Comments from Private Sector Housing:

Application No: AW/151/20/PL

Site Address: 17 Nyewood Lane Aldwick PO21 2QB

Description of Works: Change of use of former residential parenting unit (C2 Residential Institution) to 9 bed House in Multiple Occupation (Sui Generis). .

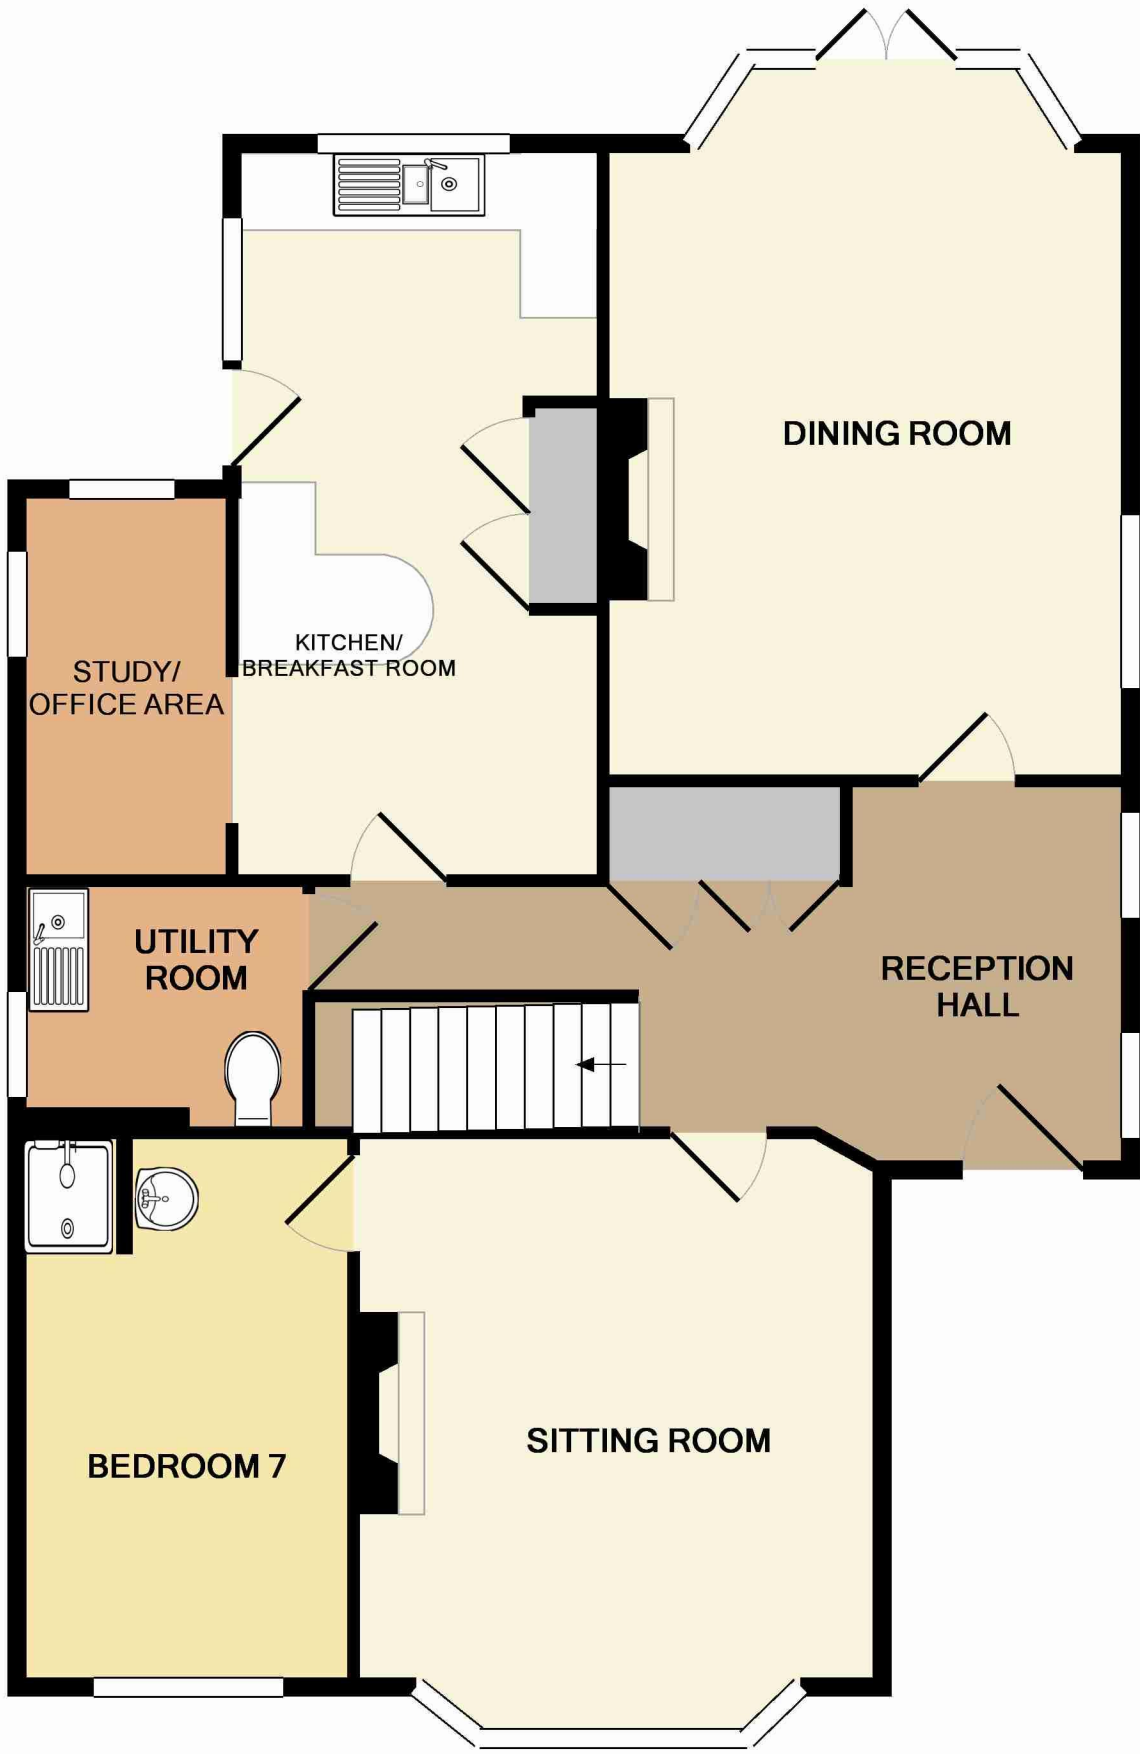
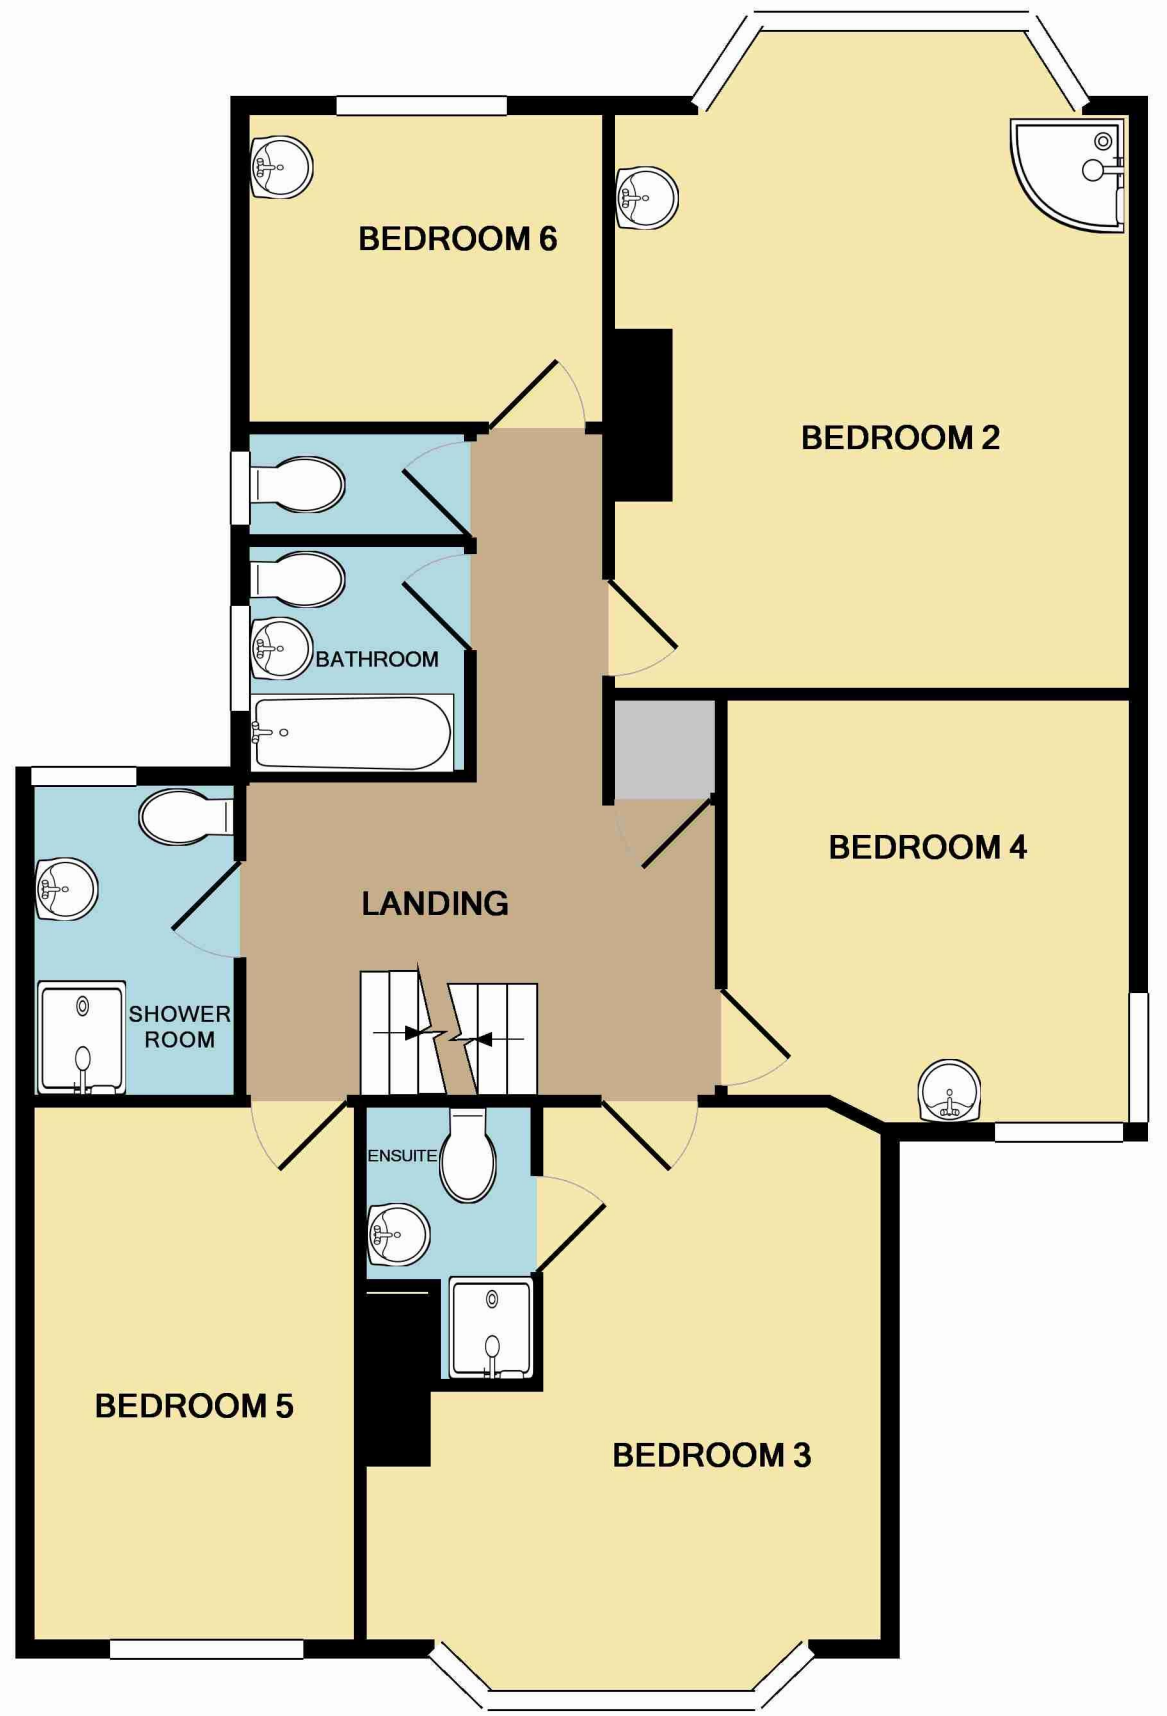
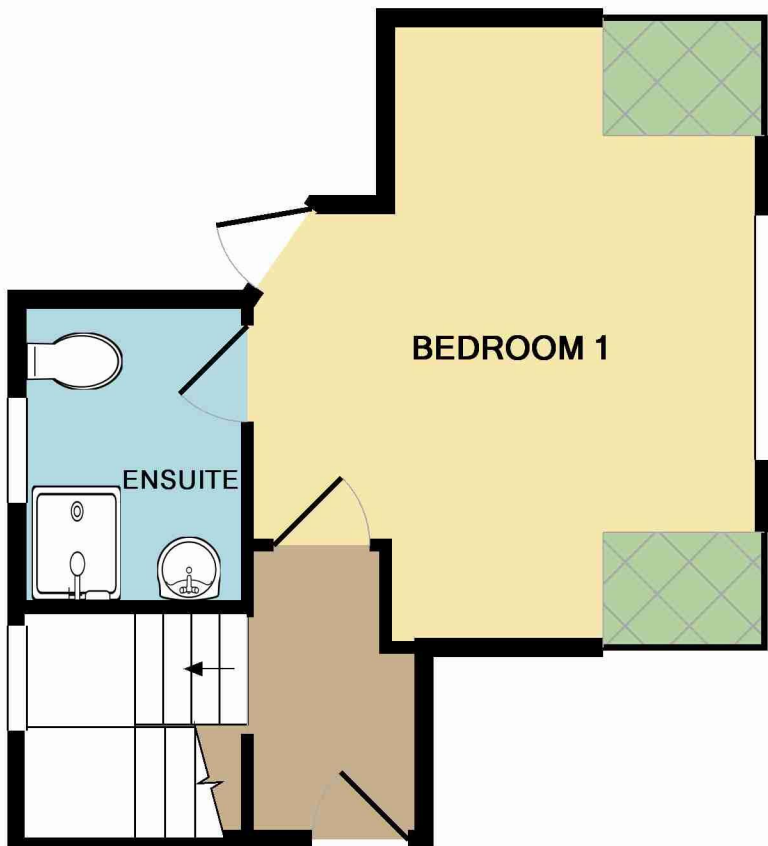
- A room where the only escape route is through another room is termed an “inner room” and poses a risk to its occupiers if a fire starts unnoticed in the outer room. In this application, the inner room is bedsit 7, with the outer room being the Sitting Room. For this to be acceptable, the following fire safety precautions must be implemented:

- Smoke detection, which is interlinked with the main fire alarm system and has an integral battery back-up, must be installed in both bedsit 7 and the Sitting Room.

- An FD30S fire door installed at the entrance to bedsit 7 (between Bedsit 7 and the Sitting Room) fitted with an overhead self-closing device, 3 fire-rated hinges, intumescent strips and cold smoke seals.

- The window in bedsit 7 must meet the requirements of an escape window, as detailed on page 16 of LACoRS fire safety guidance.
- A 30 min fire resisting escape route must be provided, which would include providing a 30 minute fire resisting and self-closing fire door (FD30S standard) to all risk room doors (bedsits, kitchen, sitting room and dining room).

The maximum number of persons that may occupy this property will likely be limited by the number of washing facilities available. Where 2 bathrooms are available, the maximum number of persons that may share these facilities is 10. It is noted that Bedsit 1 and Bedsit 3 are proposed to have en-suite facilities, but it is difficult to confirm a definitive maximum occupancy without knowing the size of each room (kitchen, dining room, sitting room and bedsits). The applicant is advised to refer to the Arun District Council's HMO Standards for further guidance on room sizes and facilities, dependant on the number of intended occupants.

- The floor plans submitted show 2 doors opening, presumably to the open air on the second floor. If this is correct, the external surface must be load bearing and suitable for occupants to use. A balustrade or barrier of no less than 1100mm in height must be installed to prevent falls from height. Any gaps in railings must not allow a 100mm sphere to pass through. An alternative could be to prevent access to these areas by blocking up, or some other solution which effectively prevents access to any unprotected areas.
- Any windows opening above 4.5 metres from ground level must be fitted with opening restrictors.
